From:
Sent: 17 February 2026 12:48
To: louise.bearcroft@kirklees.co.uk; DC Admin
Subject: Objection to Planning Application 2025/92737 and 2025/92713

Ms Bearcroft
Subject Planning Applications:
2025/61/92713/E

Comments / Concerns re the Latest Revised Plans

Drainage Layout

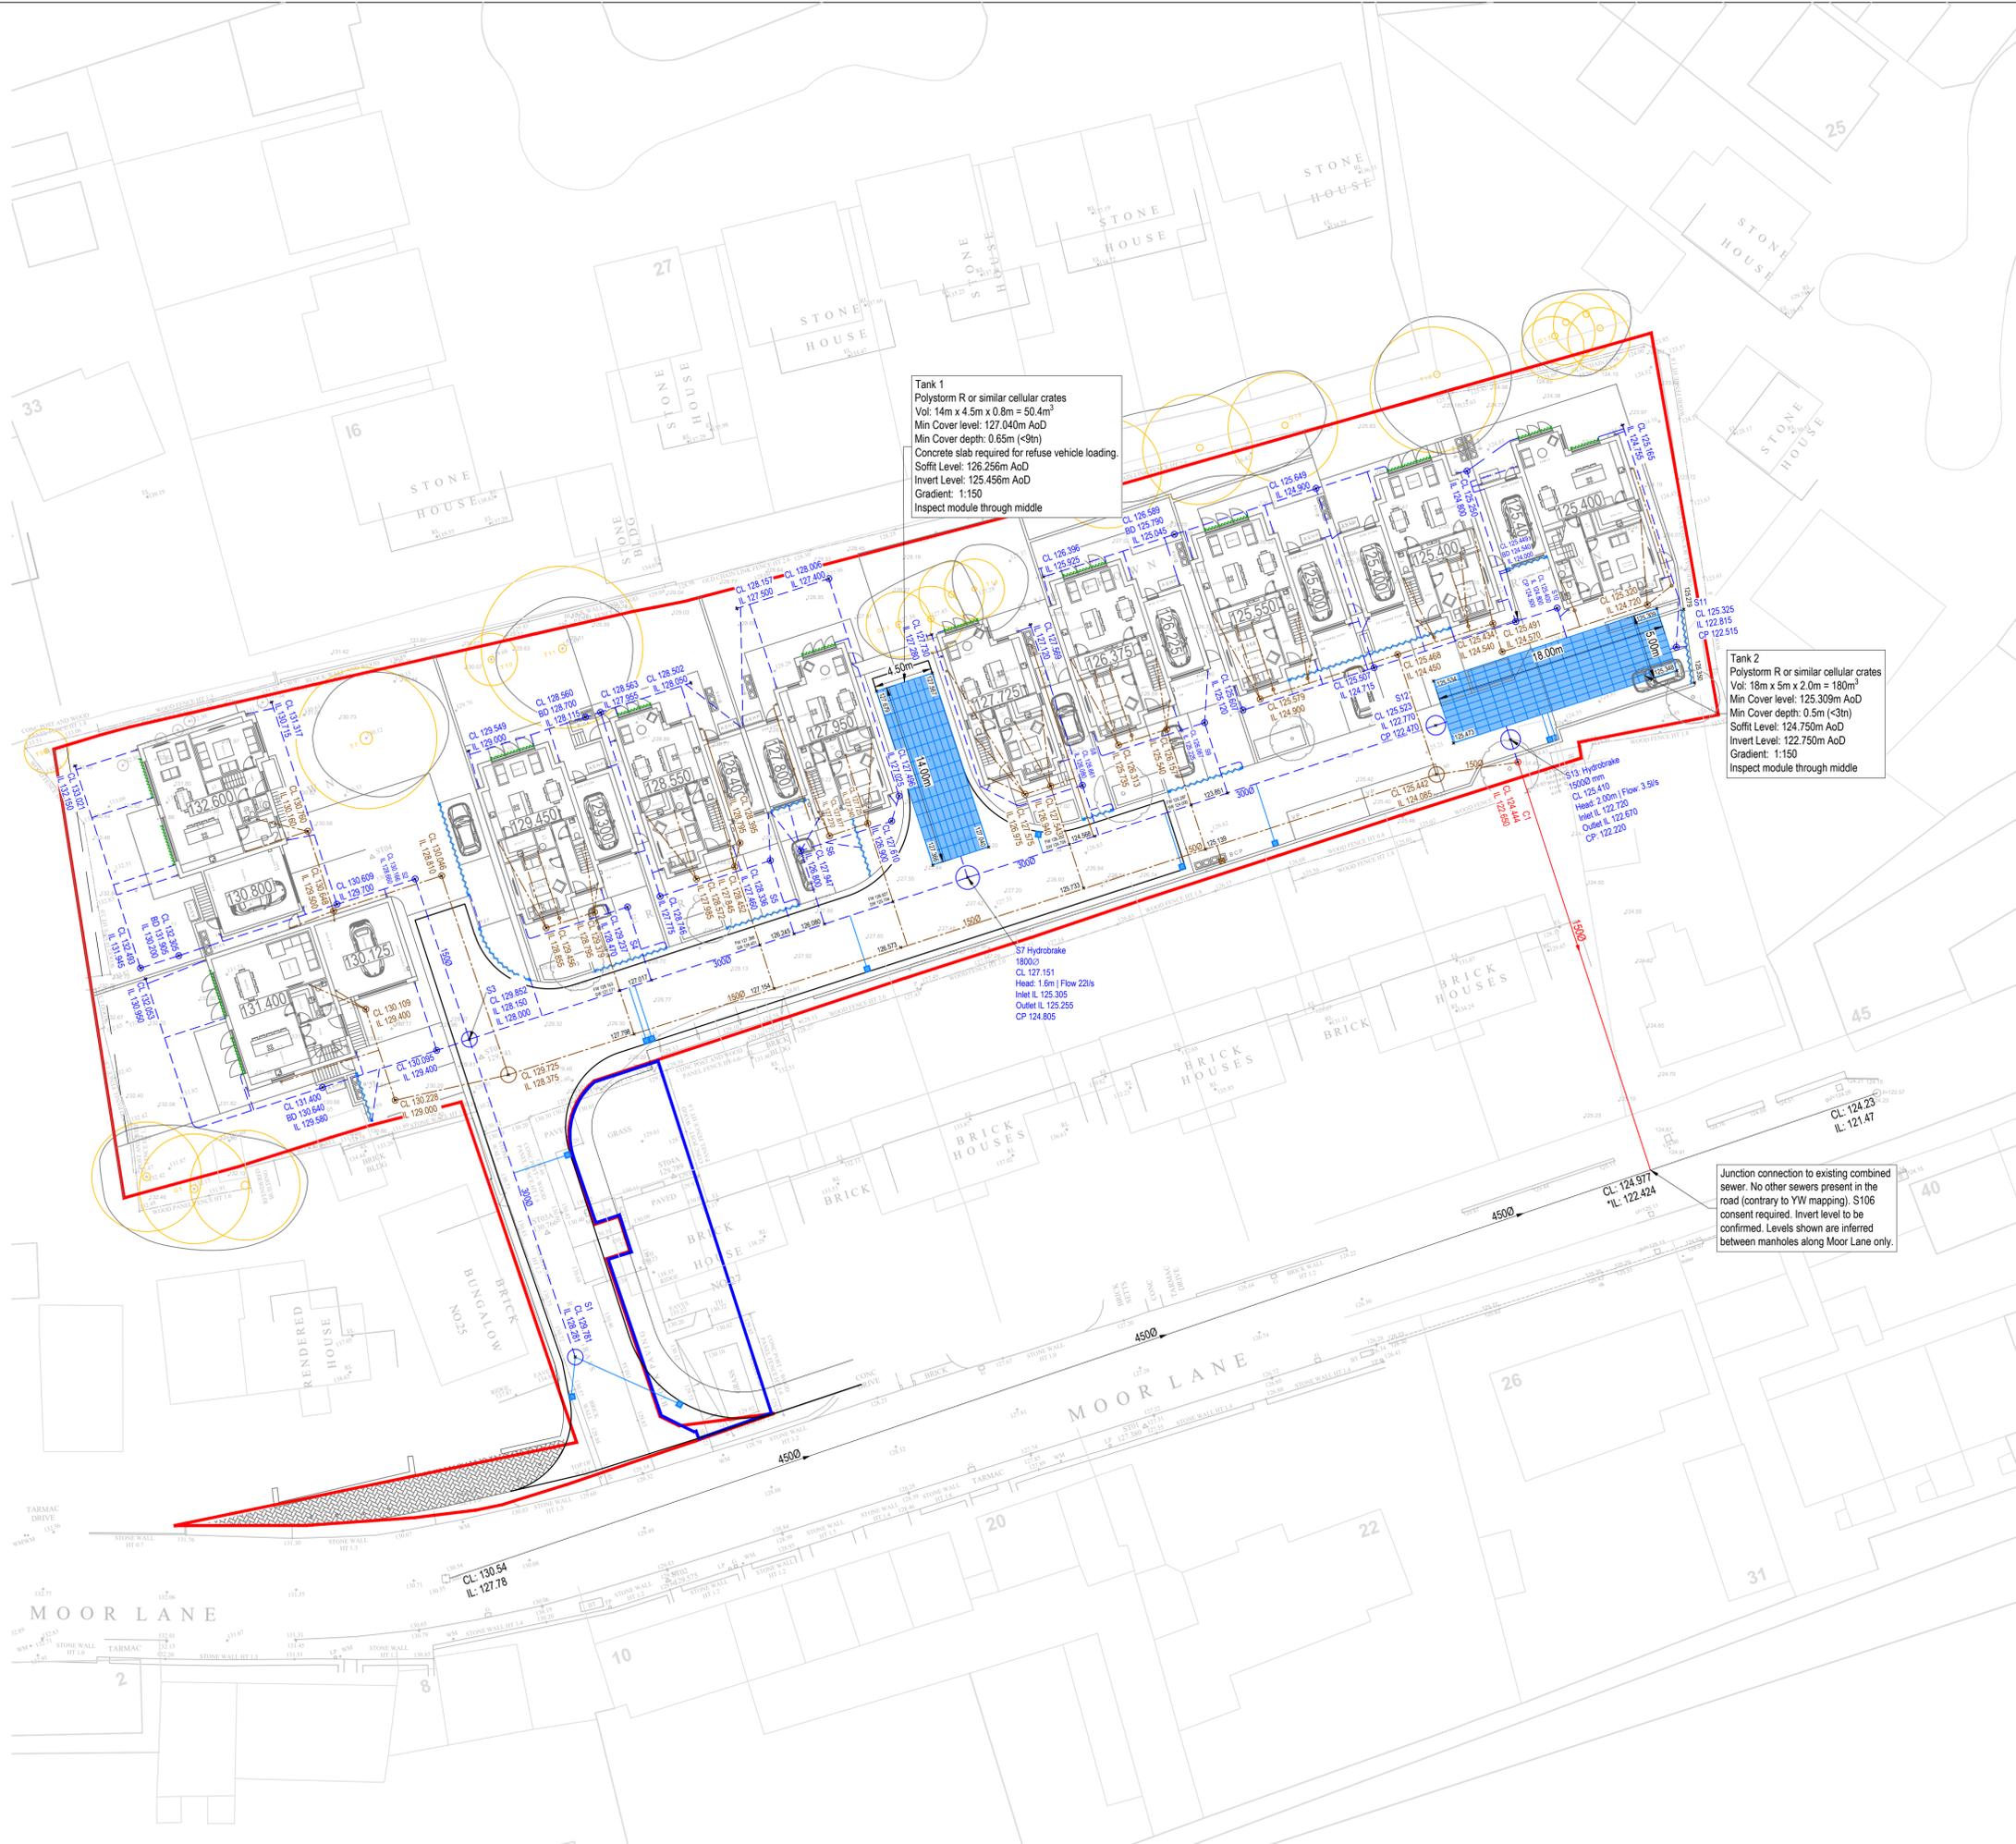
The Flood exceedance route is still shown routed into the private garden of 21 Summerdale, which from my research is illegal, unless permission is granted by the owner. Not only is this of major concern to them, but also other residents of Summerdale.
